CDS is requesting comment on the following short plat application: SP-24-00009 Black. Links to the file materials can be found below. The comment period will end **August 12, 2024, at 5pm**. CDS will assume your agency does not wish to provide comment if not received by this date. Please let me know if you have any issues accessing the materials.

RE: SP-24-00009

TO: All Staff
FROM: Public Works Plan Review Team
DATE: August 12, 2024
SUBJECT: SP-24-00009 Black

BLACK SHORT PLAT

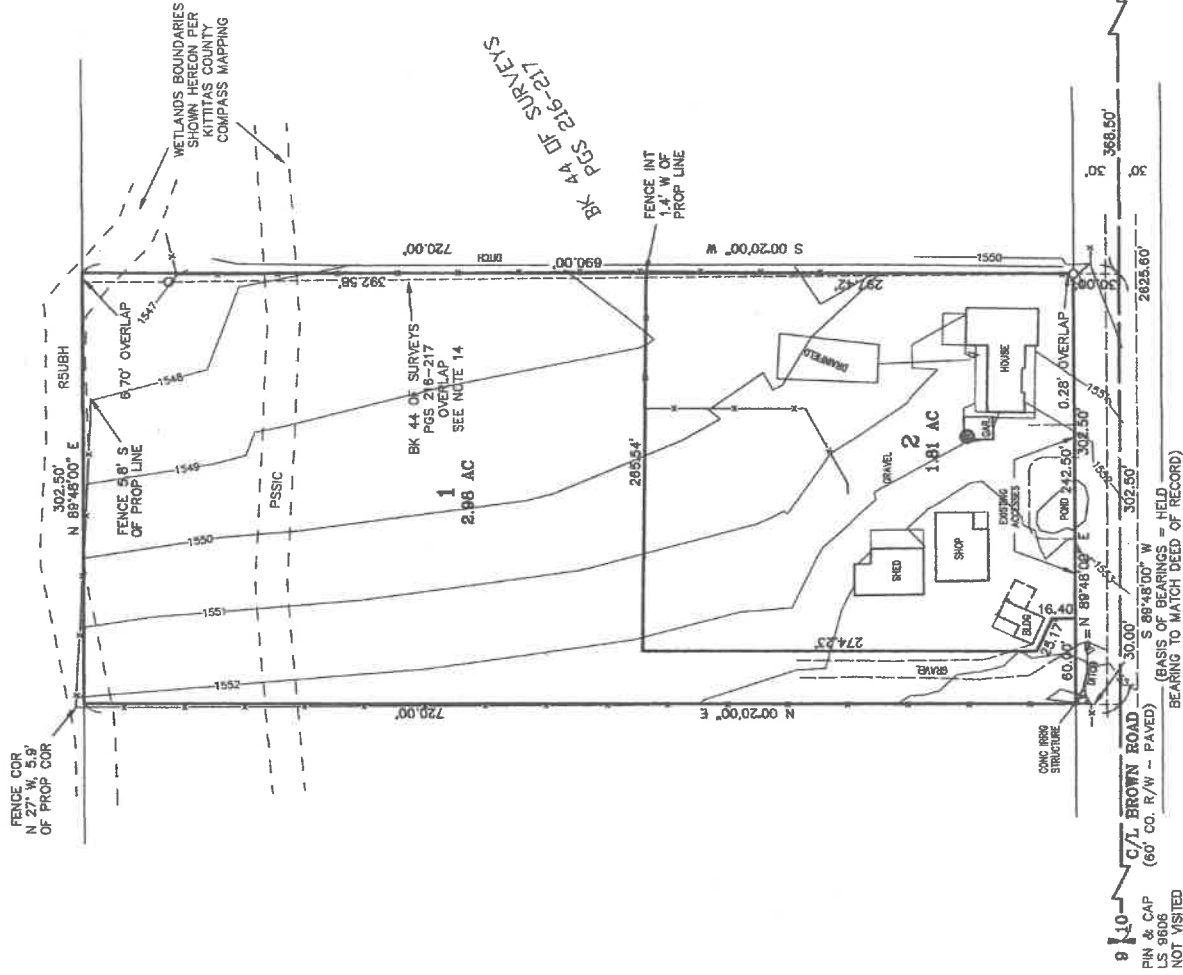
SURVEY	<p>The following review applies to the Prelim Short Plat only. Additional comments may address final submittal.</p> <ol style="list-style-type: none">1. Submittal does not meet the requirements of WAC:332-130-145 Topographic elements on maps.2. Proposed Lot 1 does not appear to meet dimensional requirements per KCC 17.29.090.3. Please show building offsets for the building adjacent to the proposed new boundary, to ensure it meets the 5' setback per KCC 17.29.060. <p>OF NOTE Lot closures were not reviewed as part of this submittal. Given the simplistic nature of the division, lot closures are not required. Title report was reviewed as part of this submittal. Ownership and legal description are fine.</p>

WDFW doesn't have many comments about this proposal, but the watercourse along the northern portion of this parcel appears to be an irrigation return. This feature is worth mentioning because of how entrenched it is and that it poses potential erosion concerns in the future. This feature also flows directly to the Yakima River, so ensuring good water quality in this watercourse helps ensure good water quality in the Yakima River and protection of aquatic life in the river. For this reason, we recommend future building setbacks treat this water feature with adequate riparian setbacks of at least 100 feet.
